Consultation Response from: KC Environmental Health (Pollution & Noise Control)
2023/92058 - Land adj, 20, Quarryside Road, Mirfield, WF14 9QQ
Discharge of conditions 11.(land contamination) 12. & 13. (Phase II Intrusive Site Investigation Report) on previous permission no. 2020/90264 for erection of detached dwelling
Date Responded:
20th July 2023

Condition 12 – Phase 2 Investigation

Dwg Title(18649)10_Site Plan

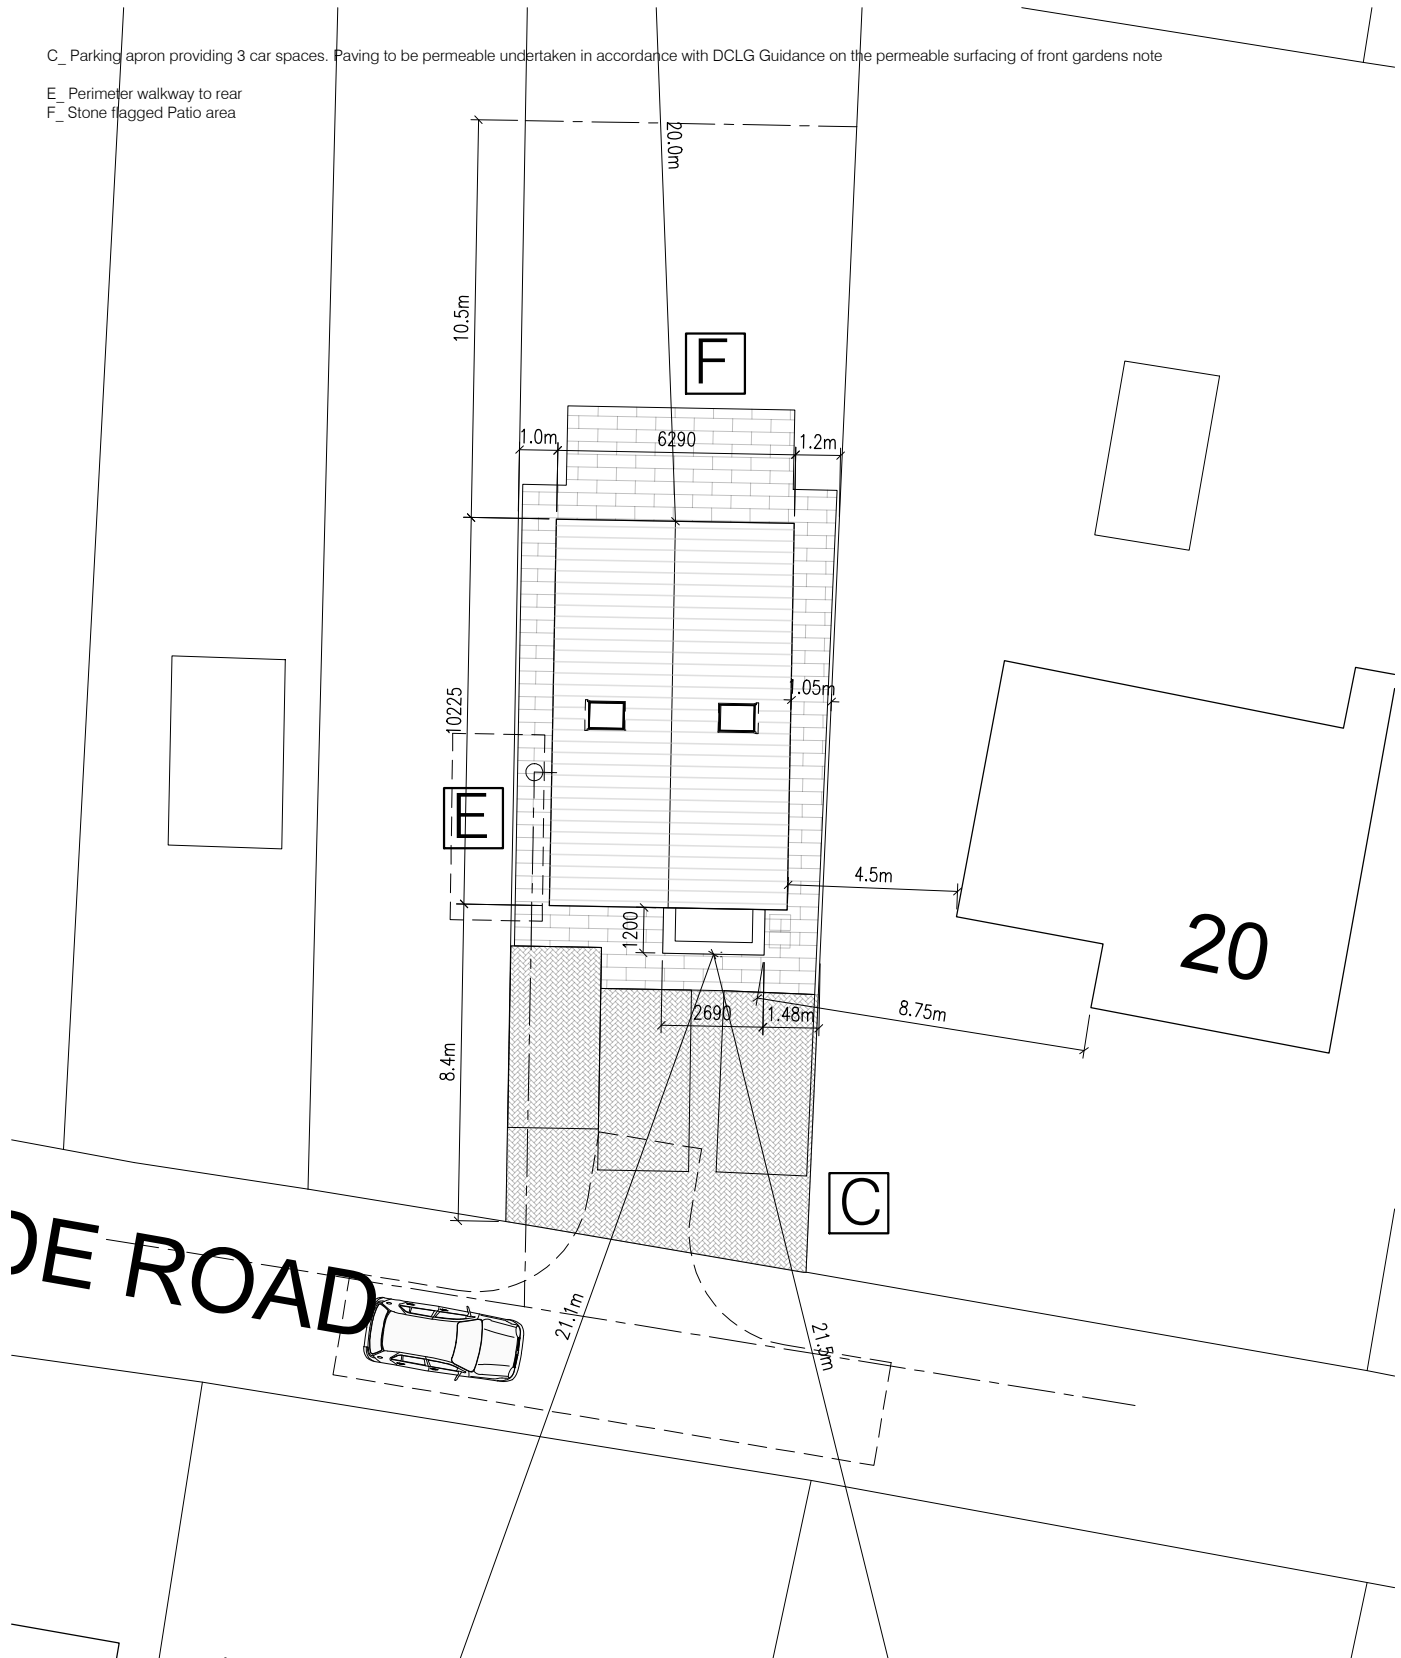
Having read the report, we need clarification on two points in relation to the Phase 2 report. The plans provided do not clearly show whether any soft-landscaping will be present to the front of the property in the vicinity of WS01 where contaminated land was confirmed. Therefore, we need a clear plan to be provided. In addition, it is unclear whether the applicant intends to import soils. We need confirmation whether any imported material is intended to be brought onto site. Lastly, if any imported material is intended to be brought onto site, we would expect soils to be tested for contaminants that are considered to pose a risk to human health in addition to those specified in the relevant British Standards to ensure that they are suitable for their intended use.
